## Development Application and Planning Proposal Review

Authority	Authority's Reference	Authority Contact	Authority Notification	Submission Due	Submission Made
NSW Planning, Industry & Environment	SSD-29999239	Sheelagh Laguna	15/03/2022	13/04/2022	13/04/2022

Address	Land Title
600 Woodstock Avenue, Rooty Hill	Lot 67 DP 804292

Environmental Impact Statement for Rooty Hill Materials Recycling Facility. Demolition of existing structures, construction and operation of a materials recycling facility processing up to 120,000 tonnes per annum of yellow lidded bin wastes and containers collected from Container Deposit Scheme (Return and Earn).

Architectural Drawings - Site Plan

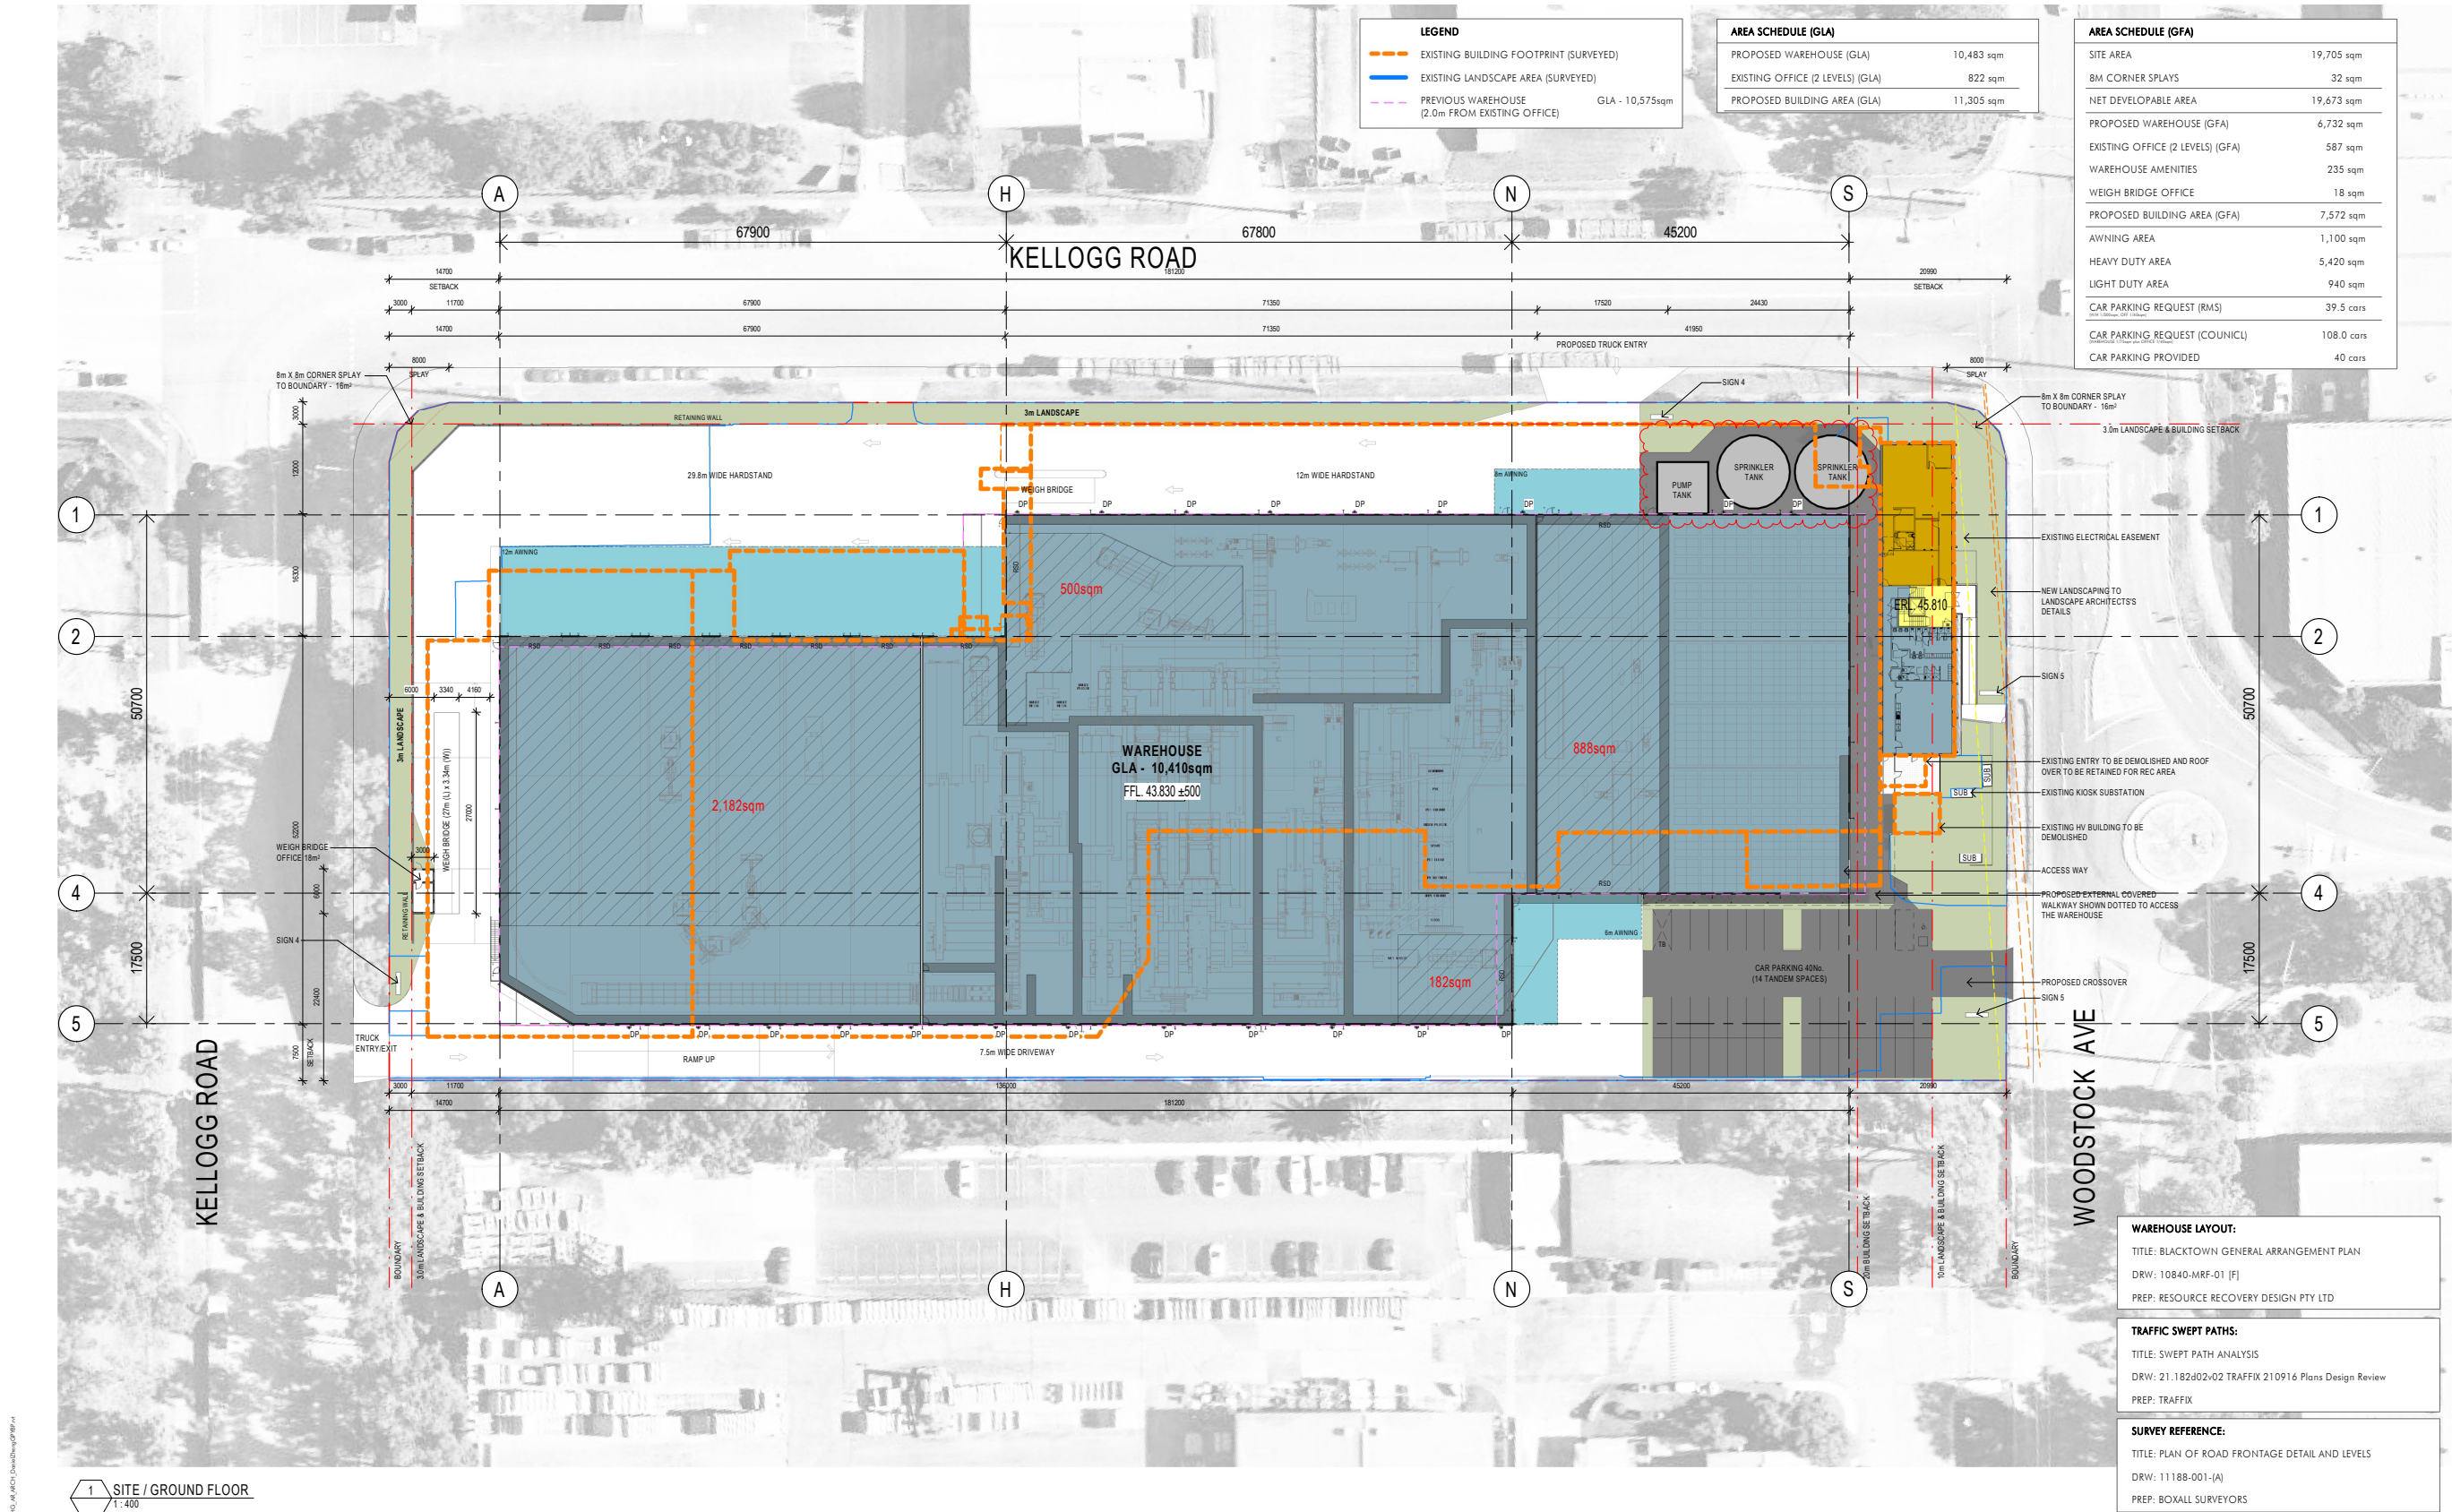
- Screening vegetation around a padmount substation should be planted a minimum distance of 800mm plus half of the mature canopy width from the substation easement and have shallow / non-invasive roots. This is to avoid trees growing over the easement as falling branches may damage the cubicle and tree roots the underground cables. All vegetation is to be maintained in such a manner that it will allow unrestricted access by electrical workers to the substation easement all times.

- All encroachments and /or activities (works) within the easement or affecting the protected works (other than those approved / certified by Endeavour Energy's Customer Network Solutions Branch as part of an enquiry / application for load or asset relocation project and even if not part of the Development Application) need to be referred to Endeavour Energy's Easement Officer for assessment and possible approval if they meet the minimum safety requirements and controls. However please note that this does not constitute or imply the granting of approval by Endeavour Energy to any or all of the proposed encroachments and / or activities within the easement. To resolve any easement management matters direct contact with the Easement Officer should be made.

- The minimum required safety clearances and controls for buildings and structures and working near overhead power lines must be maintained at all times. If there is any doubt whatsoever regarding the safety clearances to the overhead power lines, the applicant will need to have the safety clearances assessed by a suitably qualified electrical engineer / Accredited Service Provider (ASP).
